Your Ref: OWPC16359
Our Ref: EP/138/17/PL 29-09-2017
Please ask for:
Mrs A Gardner

Demolition of existing buildings & erection of 3 No. dwellings with associated parking,
alterations to existing access & relocation of staircase to flats.

Land Rear of Beechlands Cottages Beechlands Close East Preston

Thank you for your internet representation made on 16th November 2017 which has been recorded as '**an objection**' with the comments as follows:

Proposed Site Plan, Block Plan
and Location Plan

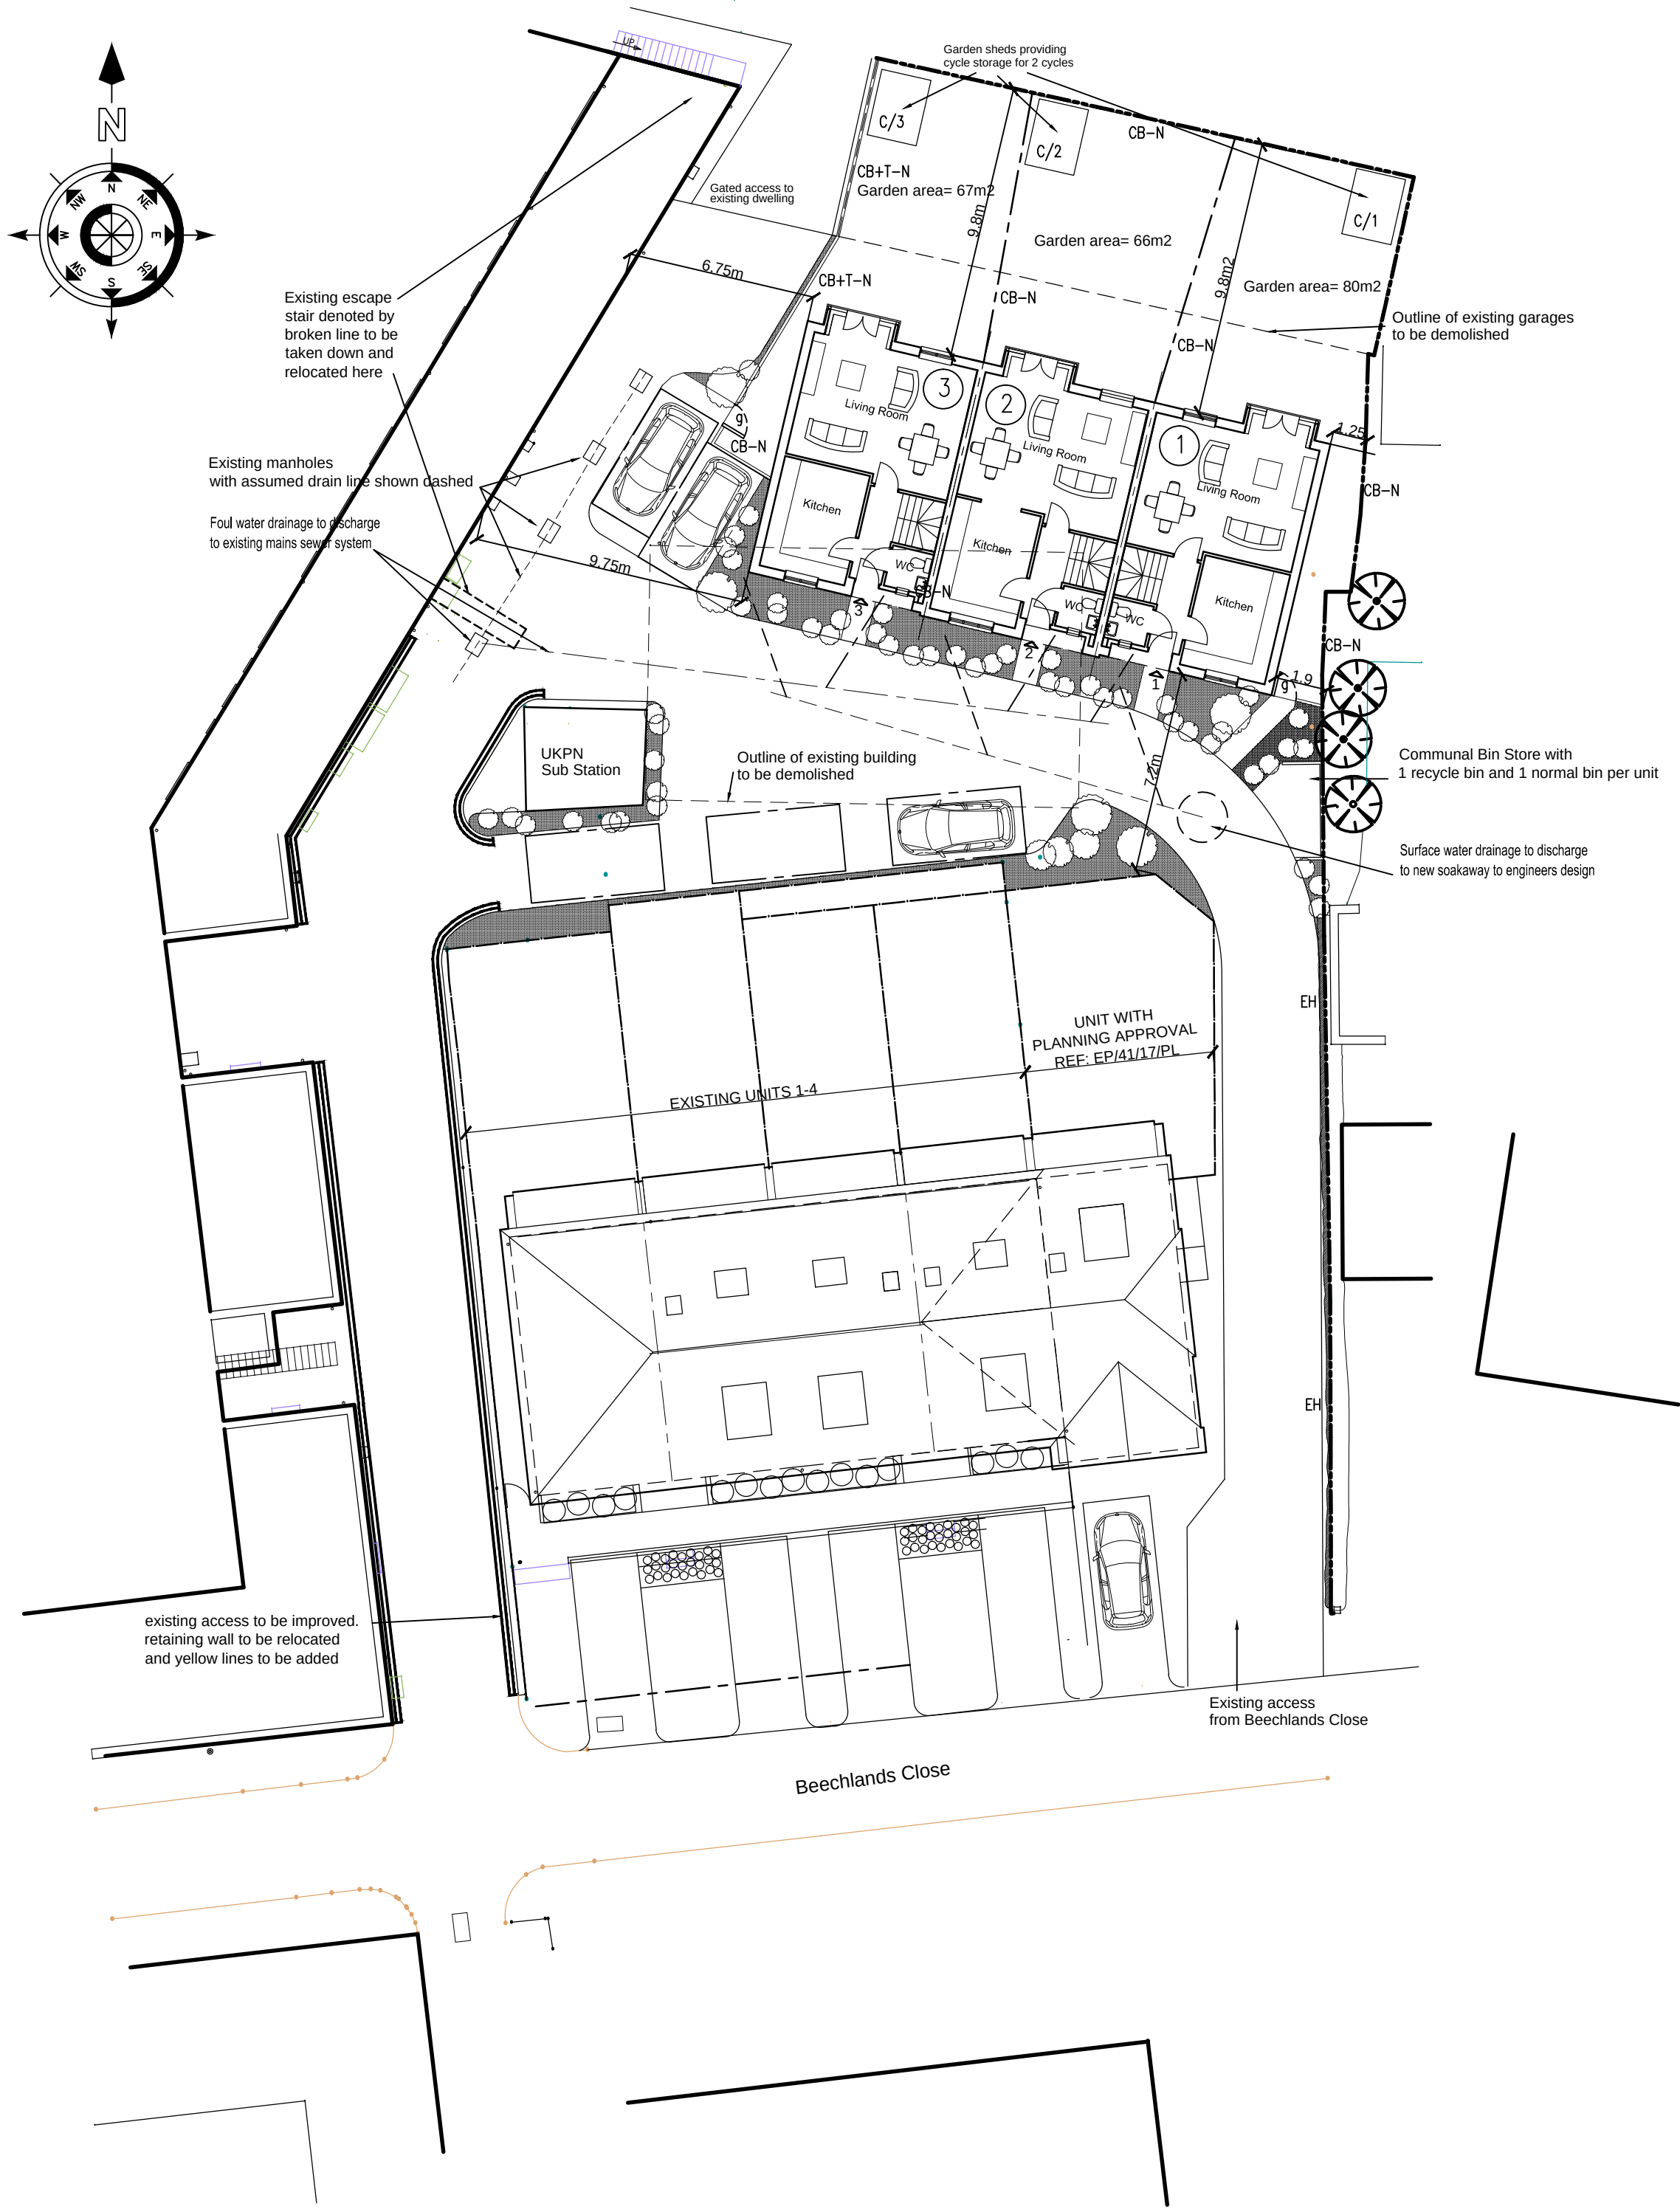
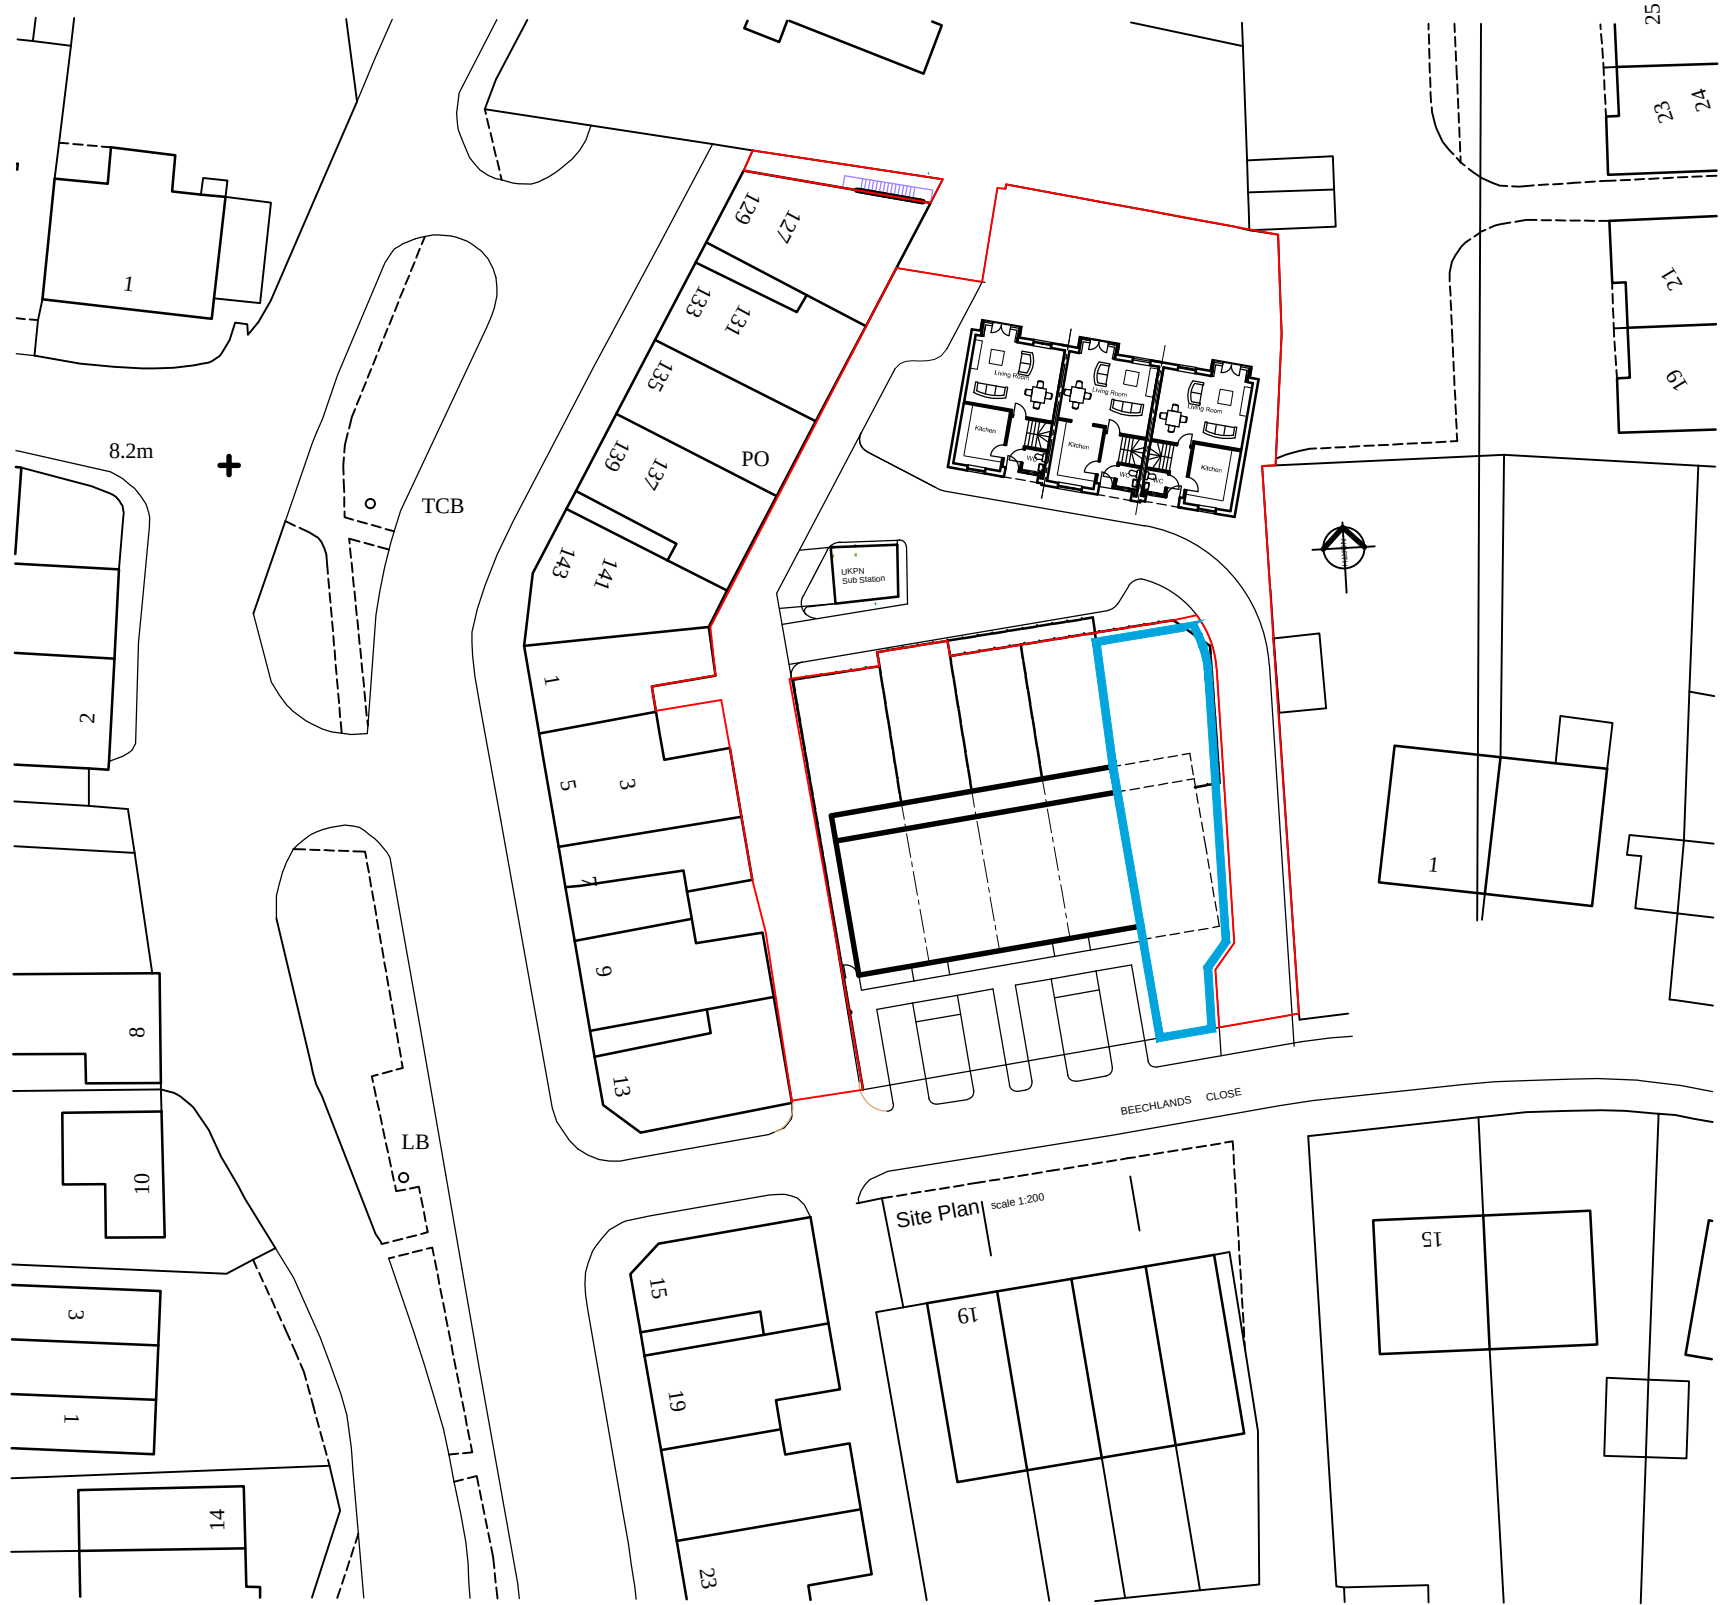
The development, and especially the position of the proposed parking places, would hamper access to the vehicle entrance to 125 North Lane, and access for commercial vehicles delivering to the rear entrances of the shops at 127-143 North Lane. The development would have an unacceptable adverse effect on the use of these properties, again contrary to Policy GEN7 (iv) of the Arun Local Plan.

The provision of 5 parking places is unrealistic. One place is between an electricity substation and another building; a car's door could not be opened in this position. Another space partially obstructs the vehicle entrance to 125 North Lane and could not therefore be used. The three remaining spaces are too few for three three-bedroomed houses. The proposal is therefore contrary to Policy 1(ii) of the East Preston Neighbourhood Plan.

DRAWING TITLE
Proposed Plans and Elevations

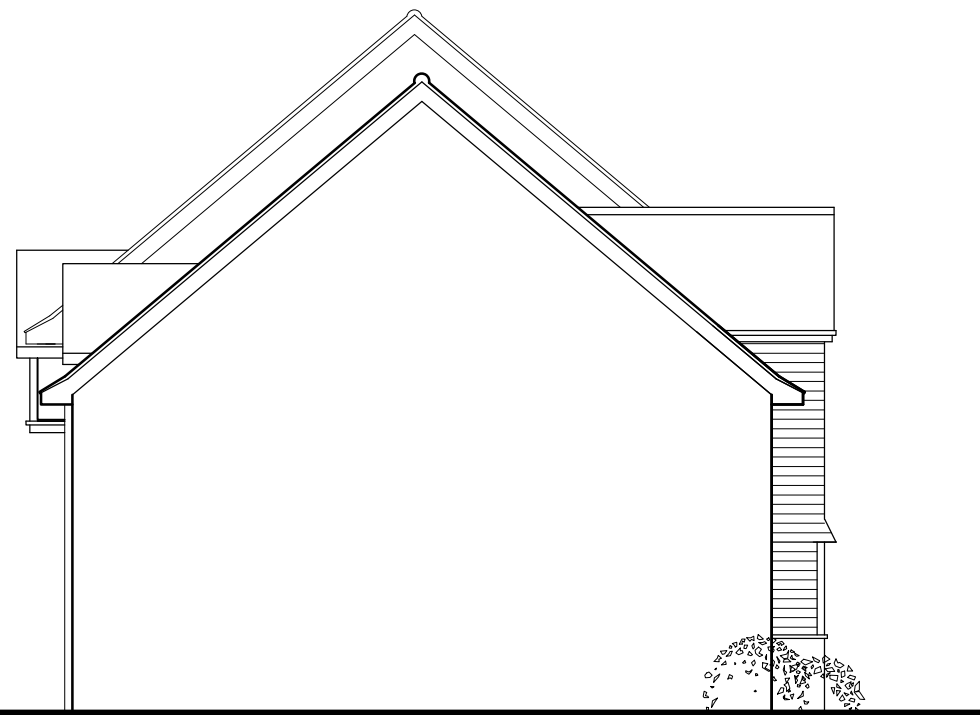
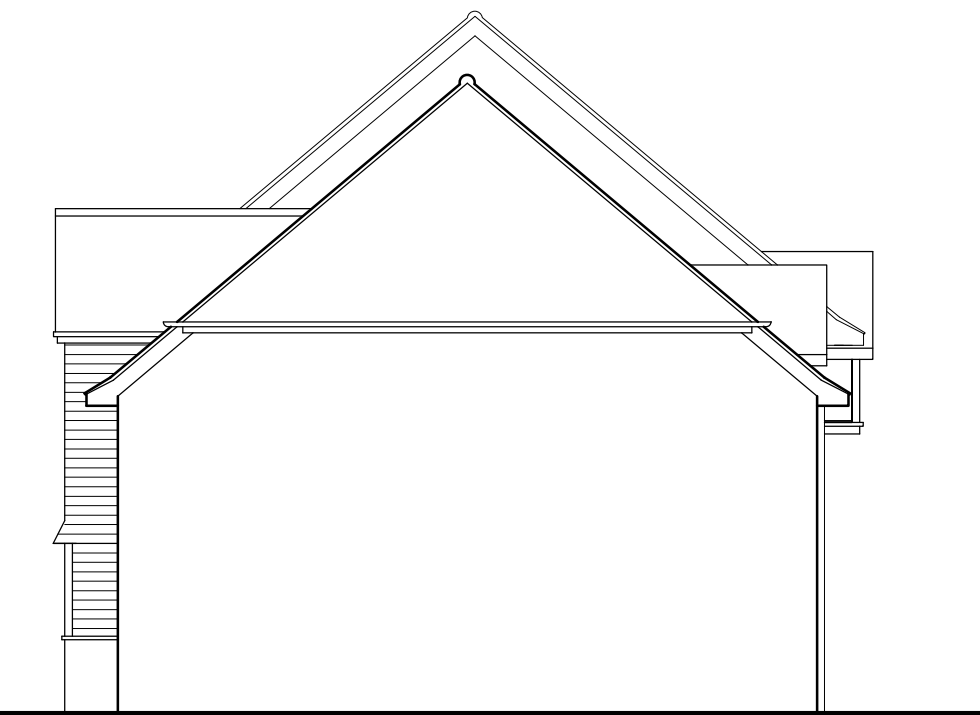
The proposed terrace of three houses would be built so that the upper windows were 18-21 metres from the upper windows of the four existing houses in Beechlands Close and the fifth house for which planning permission has been give. At this proximity overlooking would occur and the development would have an unacceptable adverse effect on the occupiers of these adjoining properties. The development would therefore be contrary to Policy GEN7 (iv) of the Arun Local Plan.

The character of the proposed terrace, at the rear of the existing properties in Beechlands Close and North Lane, is wholly alien to the character of the area. It is therefore contrary to Policy 1 (i) of the East Preston Neighbourhood Plan
